PERMIT ISSUED
Permit Number: 060976
AUG - 8 2006
CITY OF PORTLAND

This is to certify that DRAGON PRODUCTS COMPANY INC / Keeley Construct
has permission to Concrete Batch Plant- Roof Replacement
AT 934 OCEAN AVE 415 A004001

Proposed Project Description: Concrete Batch Plant- Roof replacement after collapse
--	---

RE: Roof Repair Building Permit Application
Dragon Products Company
934 Ocean Avenue

**NEW FRAMING PLAN**  
 1/4" = 1'-0"  
 NOTE:  
 ALL FRAMING SHALL BE 2x10 @ 16" O.C.  
 EASTERN SPRUCE NO.2 GRADE

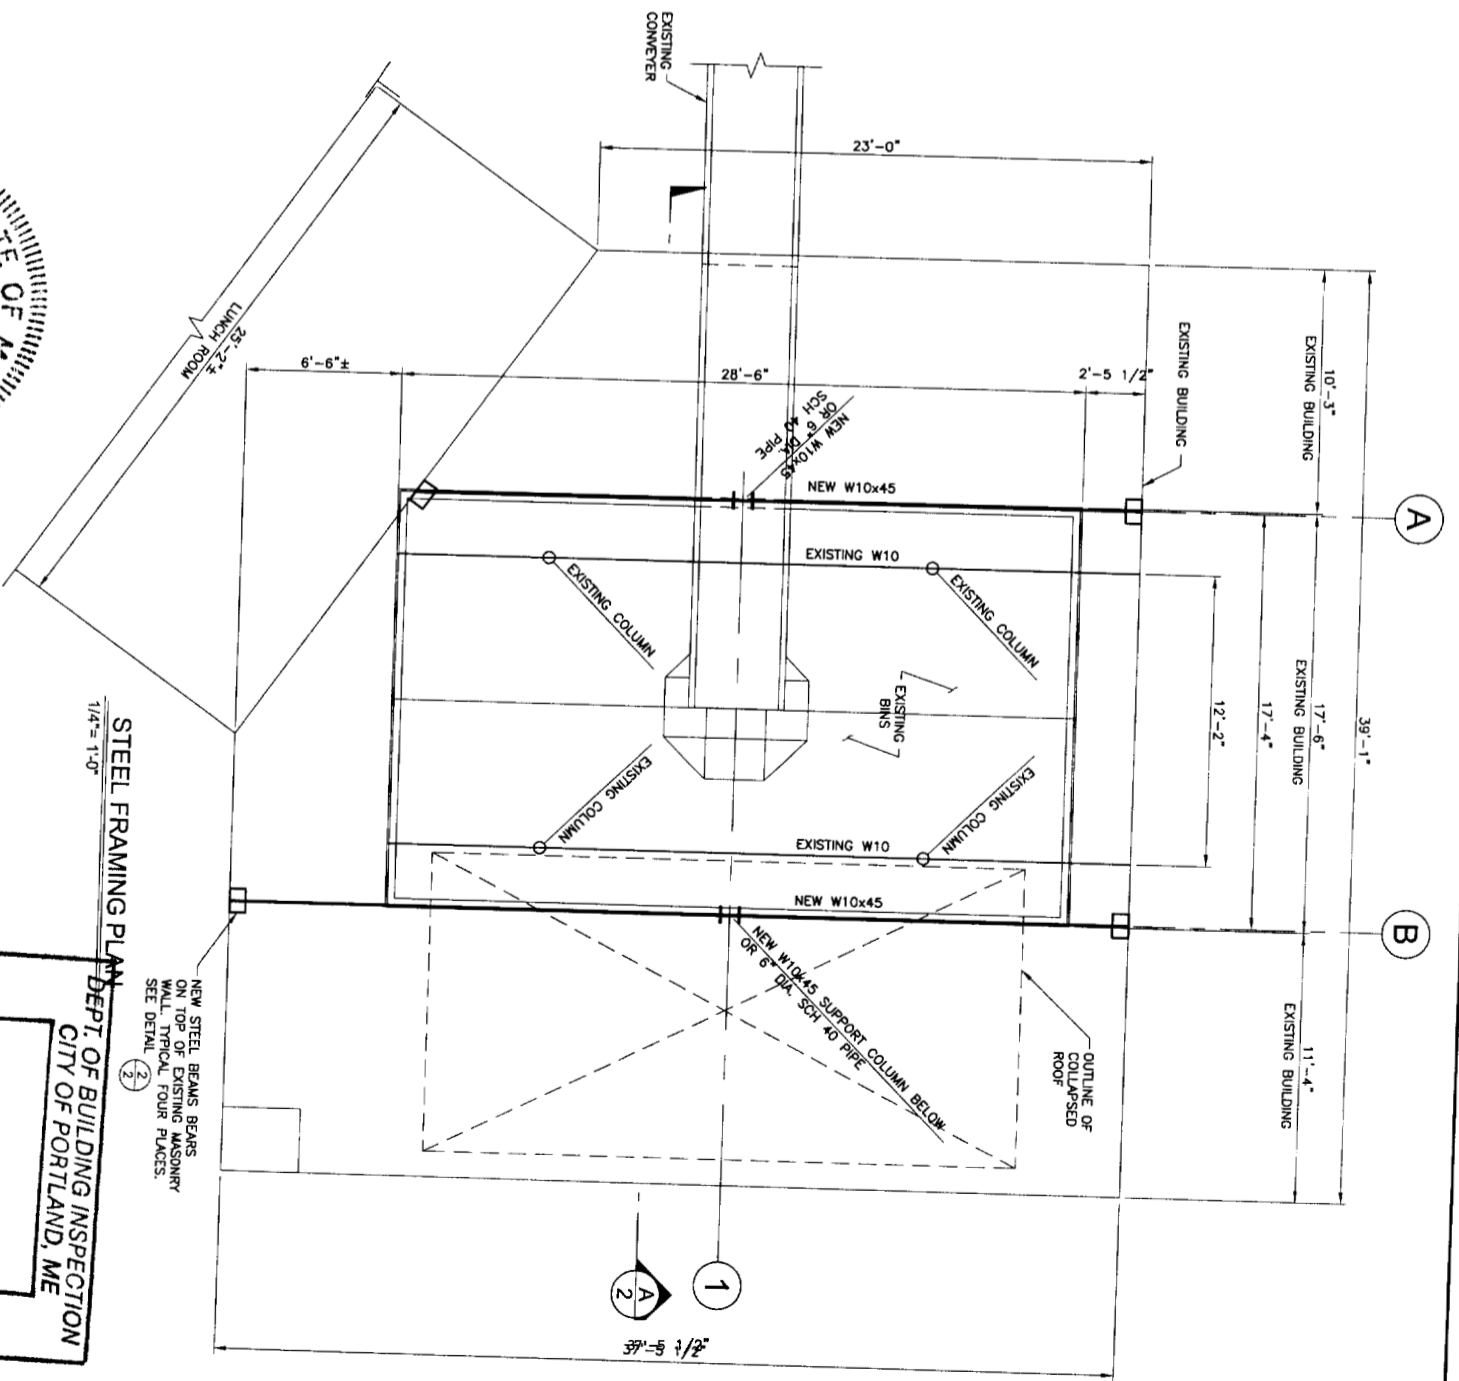
Comments:
7/3/2006-mjn: plans not stamped need Special Inspections statement, 7/7/06 got stamped plans need statement of special inspections, spoke with applicant and left message w/ project engineer.
7/21/2006-gg: received additional plans (Statement of Special Inspections). /gg

As per your request, enclosed please find 11" x 17" roof replacement construction plans with registered professional engineers stamp. My apology for the oversight in the original submittal to you of June 30, 2006.
